Planning Consultation Memo

Date	Planning Officer	Environmental Health Officer
18/10/2022	Mr Raymond Lee	Terry Vincent
Planning Application Number	Worksheet Number	
6/2022/2220/COND	WK134232

Address: Stadium Service Station Stanborough Road Welwyn Garden City AL8 6XA

Application Details: Submission of details pursuant to conditions 1 (Construction Management Plan), 2 (Detailed surface Water Drainage Scheme), 5 (Arboricultural Method Statement), 11 (Noise Impact Assessment) and 17 (Surface Water Strategy Report) on planning permission 6/2021/2260/FULL

VA4245/NM1
Charger Plant

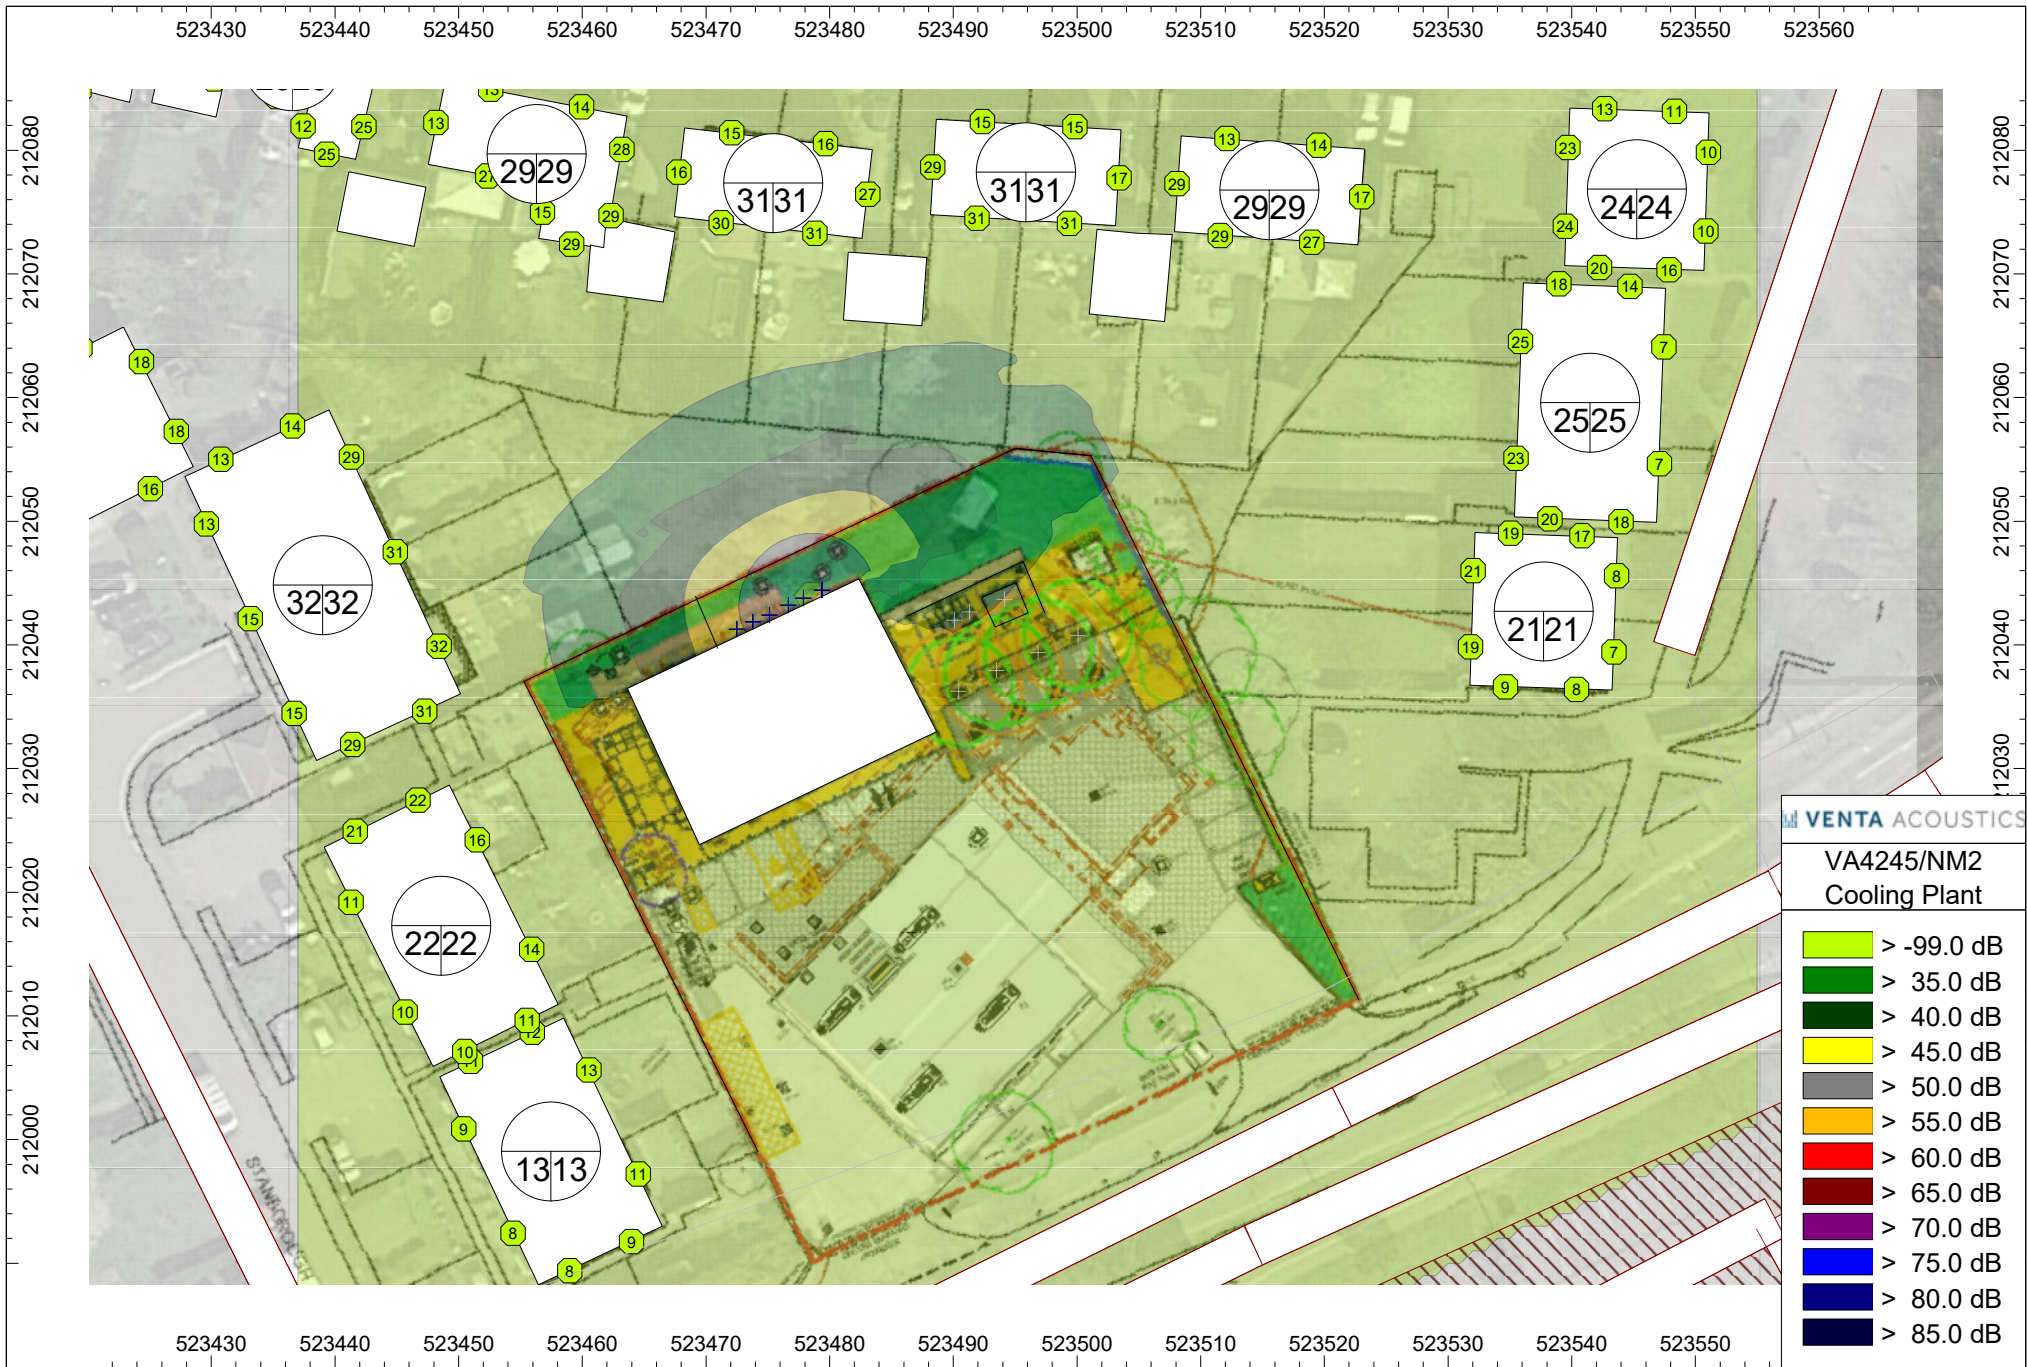
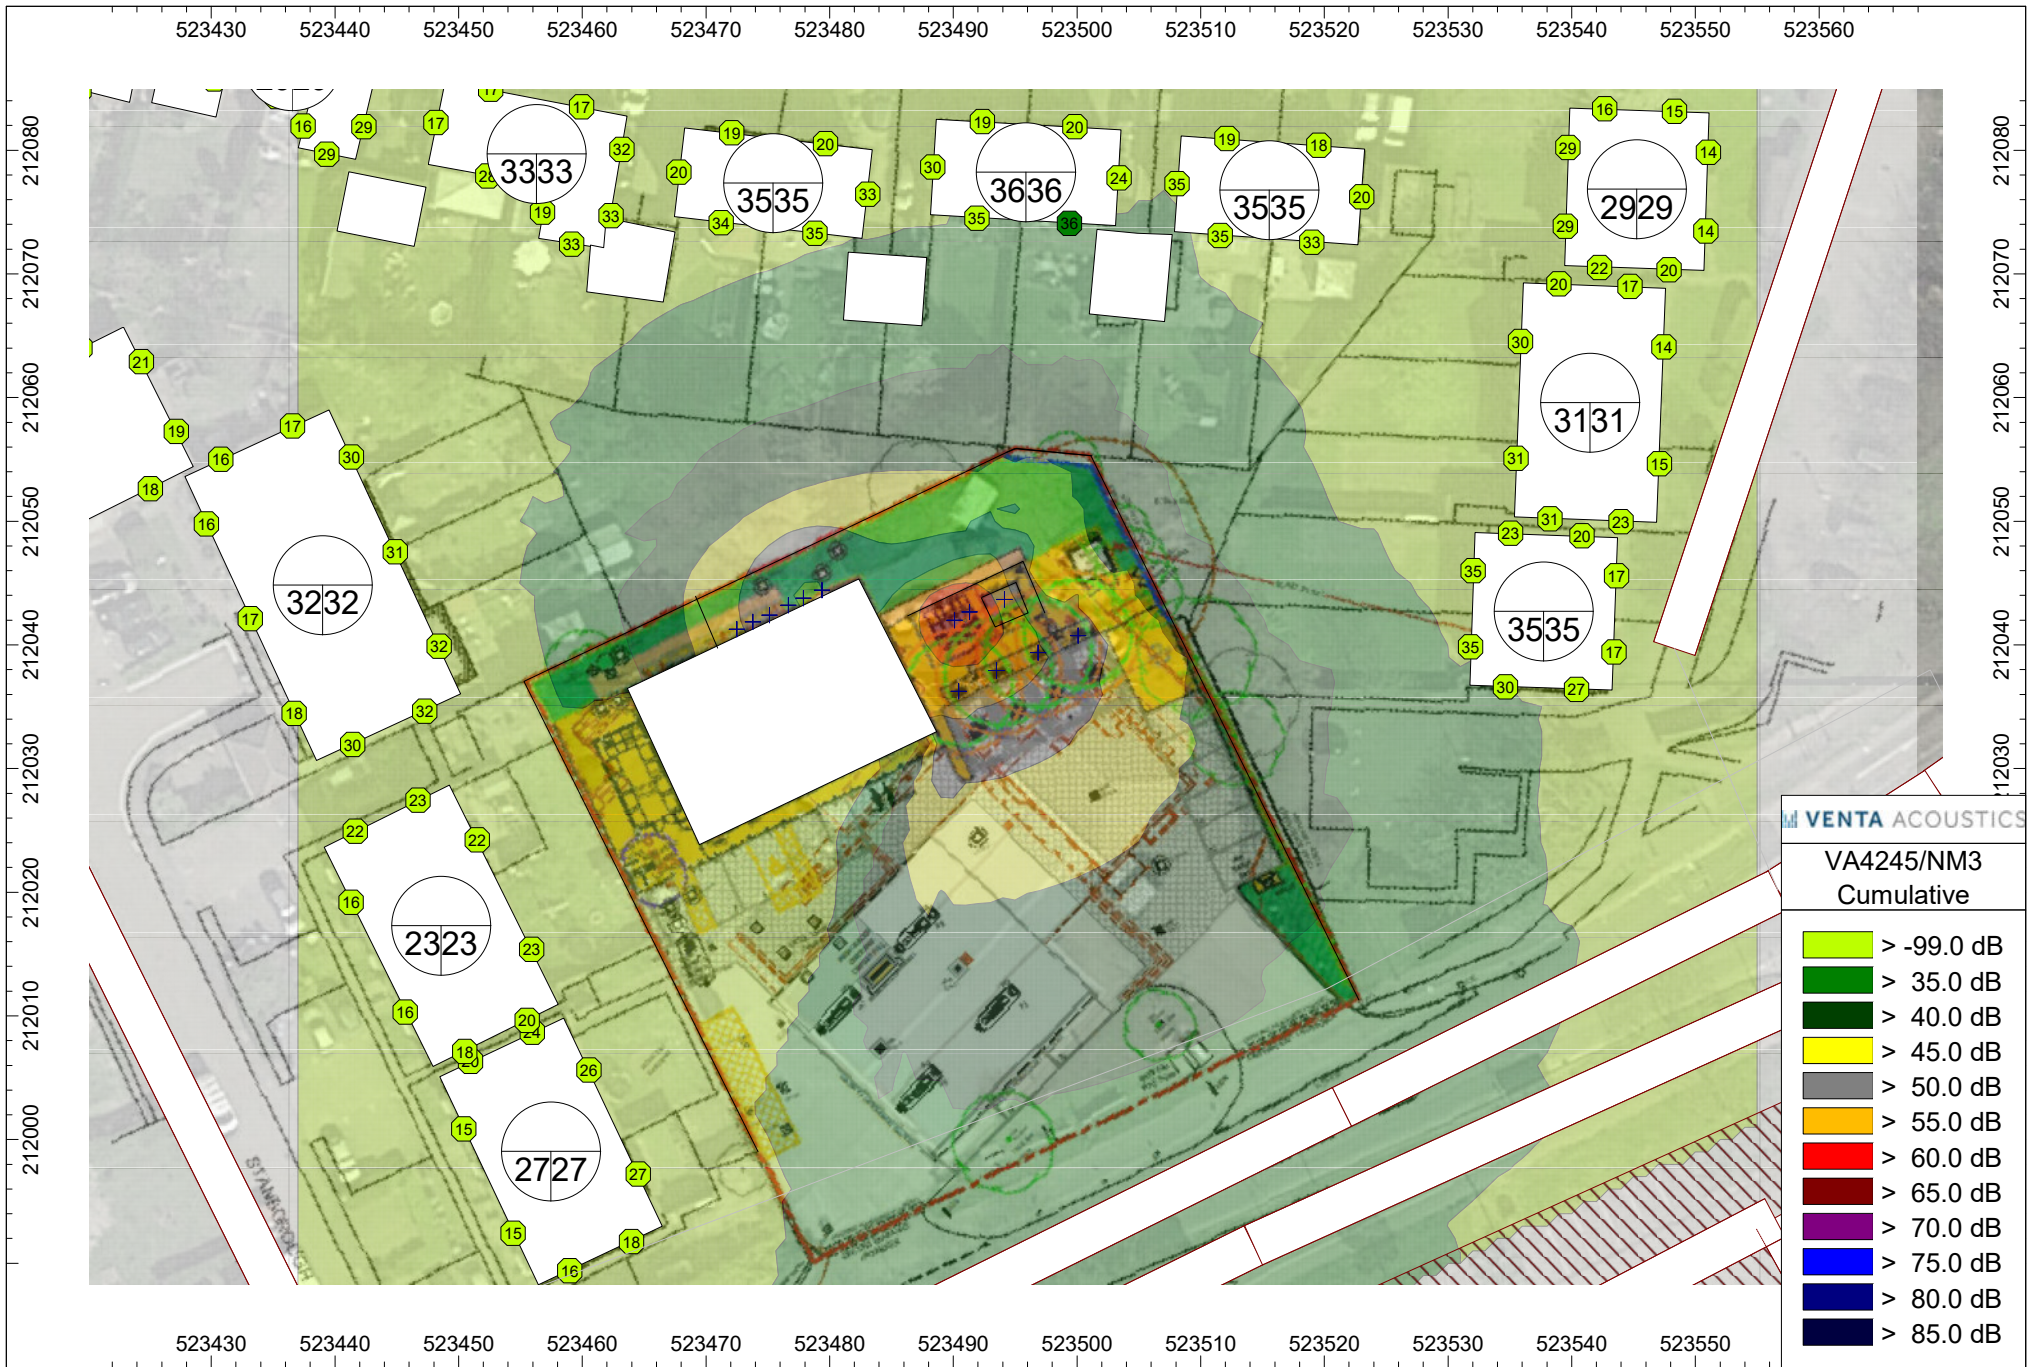
The noise report submitted by Venta Acoustics Ref: Report VA4245.220809.NIA1.2 – predicts the noise impact from the new plant as a low impact (1 dB over the background noise level).

It is important to note that this does not show compliance with condition 11. The report refers to the fact that the car wash on site is being removed reducing noise levels. It also states that the predicted impact is the worse case scenario with all plant operating.

The removal of the car wash is not relevant in this instance because the noise impact from the car wash is unknown at this time, therefore a direct noise comparison cannot be made between the car wash and the proposed plant.

In relation to all plant operating at once, it is not known how often this would occur, however, it could occur and therefore must be considered as a regular possibility.

I recommend that further mitigation measures are considered to ensure that operational noise levels comply with the requirements of condition 11. It might be wise to not only consider silencing options but presenting data on expected regularity in terms of use.
